**KIRKLEES METROPOLITAN COUNCIL
INVESTMENT & REGENERATION SERVICE**

Reference No:	2023/62/90630/W
Site Address:	53, Greenhead Road, Huddersfield, HD1 4ER
Description:	Erection of two storey extension
Recommending Officer:	Tom Hunt

DECISION – REFUSED

Officer Report

Front
1 : 50

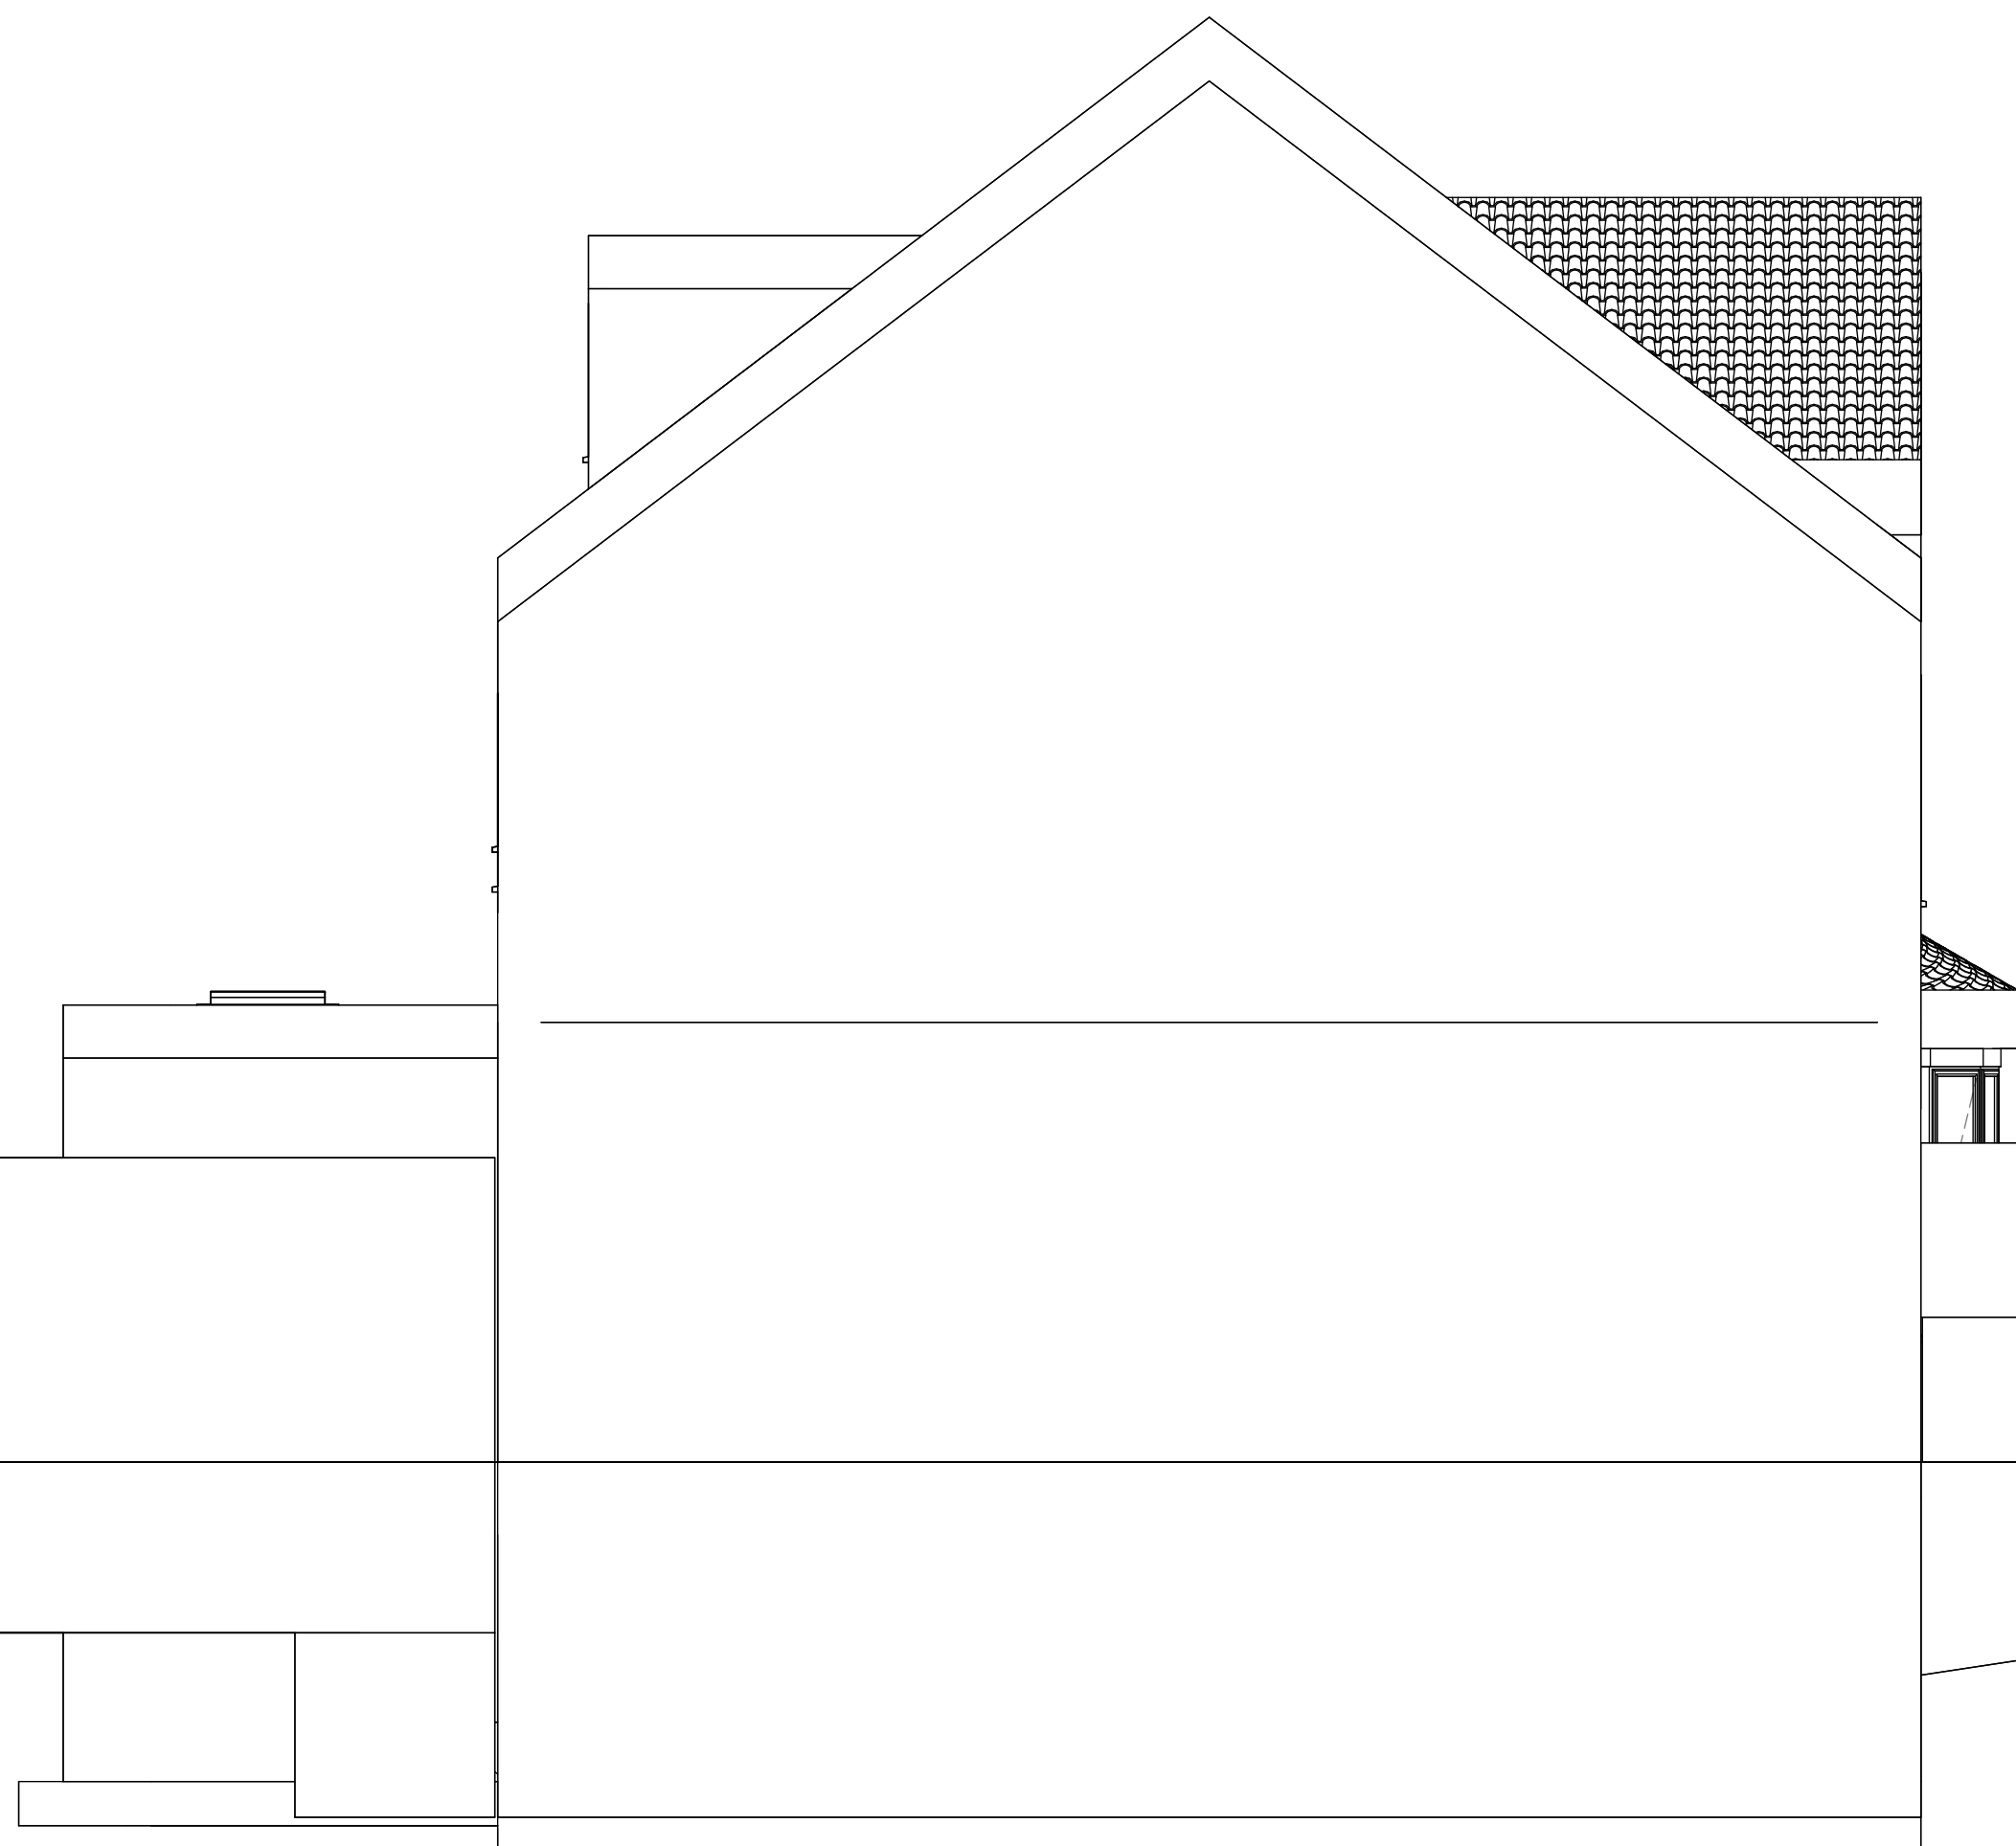
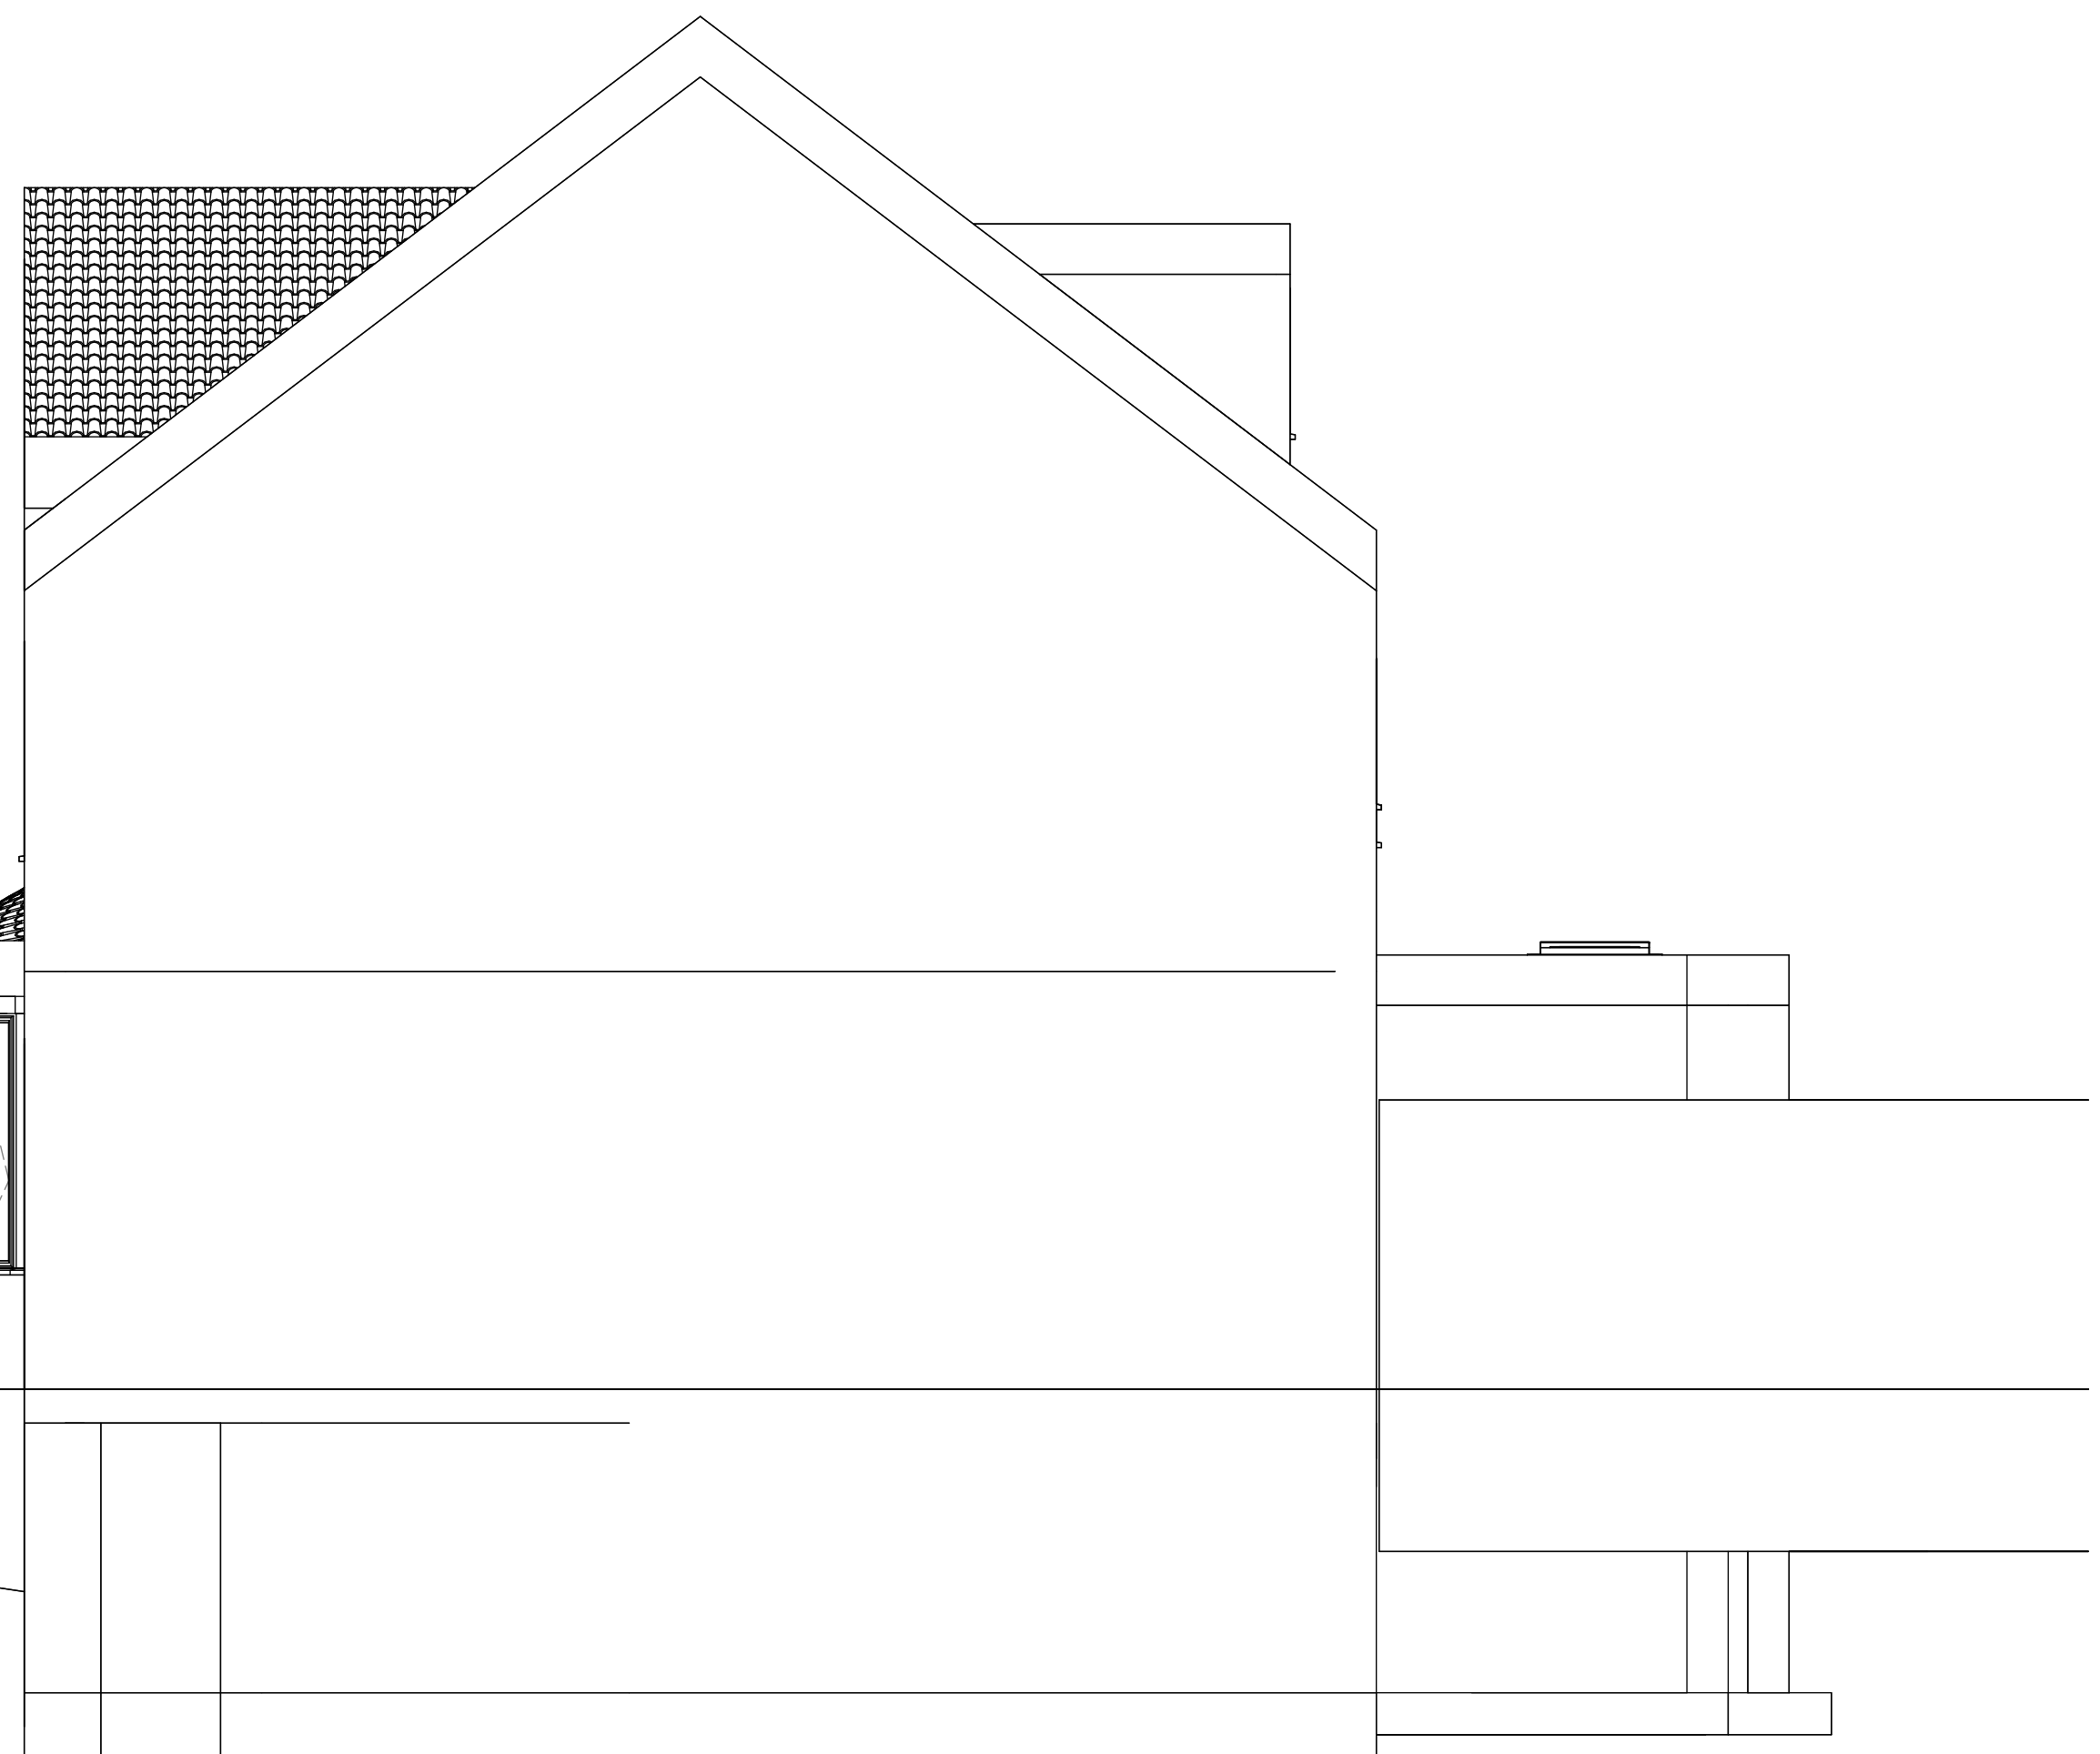
Officer Note: Existing elevation plans do not show the full extent of the gable end front feature and the proposed elevation does not definitively set out the proposed height of the rear raised area with steps.

The agent was contacted regarding plans which did not accurately set out the front elevation of the host building and had this in part corrected within submitted proposed plans. In relation to Officers concerns over the design and other considerations, the agent was not contacted during the course of the application as the scale of considered necessary would materially change the development applied for.
